From: [Downes, Scott G \(DFW\)](#)
To: [Kelly Bacon \(CD\)](#)
Cc: [Torrey, Elizabeth M \(DFW\)](#)
Subject: RE: SE-22-00005 Haase - Notice of Application
Date: Tuesday, March 15, 2022 9:38:28 AM

Subject: SE-22-00005 Haase - Notice of Application

SITE PLAN

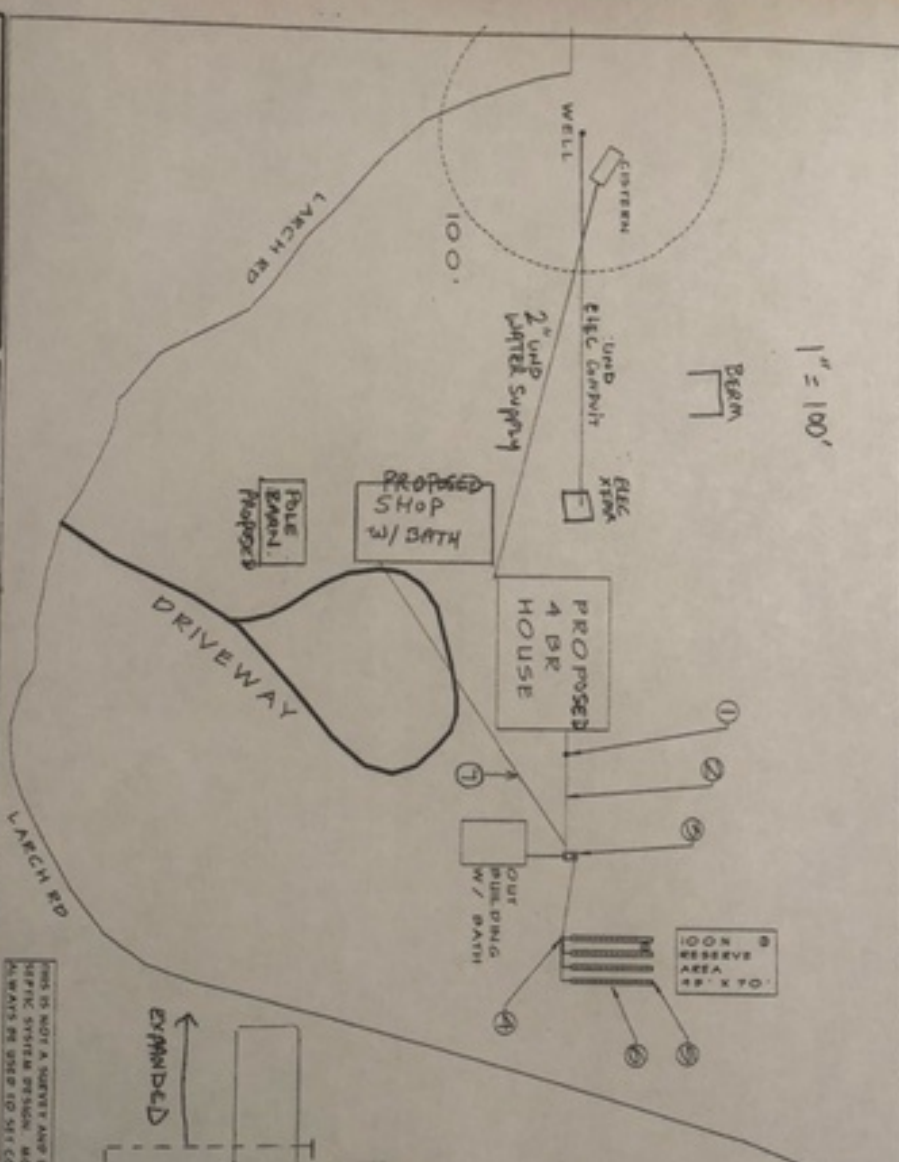
To follow up on this, there are streams on both the western and eastern ends of this property. Their site plan would need to be set back from these streams per the CAO requirements. The stream on the western edge is a Ns stream, non-fish bearing seasonal stream and on the eastern end is a disconnected portion of the North Fork Teanaway river and associated shoreline area.

Thanks for sending. I don't think the site plan results in any additional comments from us.
